**DELEGATED HOUSEHOLDER DECISION**

**Address**                    19 FAIRFIELD AVENUE RUISLIP

**Development:**          Single storey rear extension

**LBH Ref Nos:**          **13460/APP/2021/2254**

## Proposed Elevations

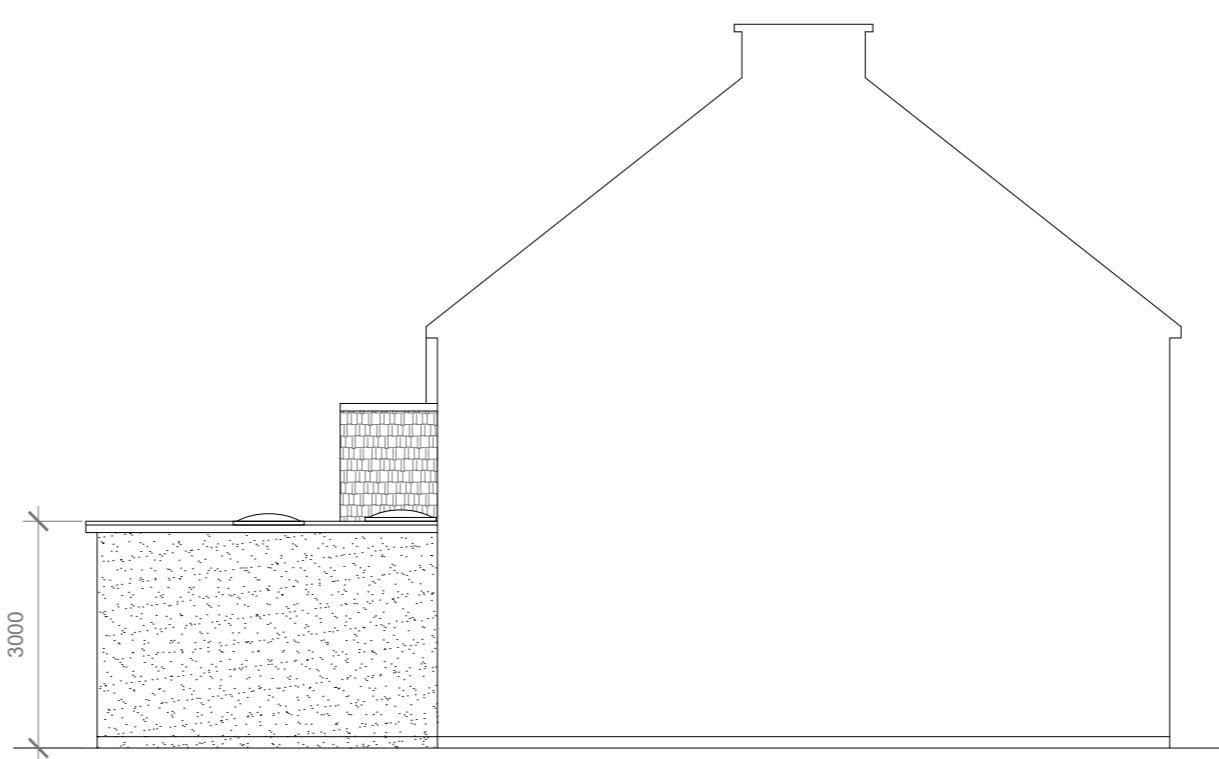
With respect to single storey rear extensions they must not be more than 3m in height if a flat roof is proposed and 3.6m deep on a semi-detached house with a plot width of 5m wide or greater. Whilst the single storey rear extension would be no more than 3m in height it would exceed the Council's standard in terms of its depth by 1m. However the extension will not cause harm to the amenity of the residents at No. 17 as this property already has a substantial rear extension. It is considered that there would not be any harm to the amenity of the residents at No. 21 given that there is already a 4.7m deep extension adjacent to this property. No side facing windows are proposed that would result in loss of

privacy. Overall the extension would not result in harm to the amenity of nearby residents by way of loss of light, outlook or privacy.

The extension would appear subordinate to the main house and would be appropriately designed as such it would not cause harm to the character and appearance of the site and the wider area.
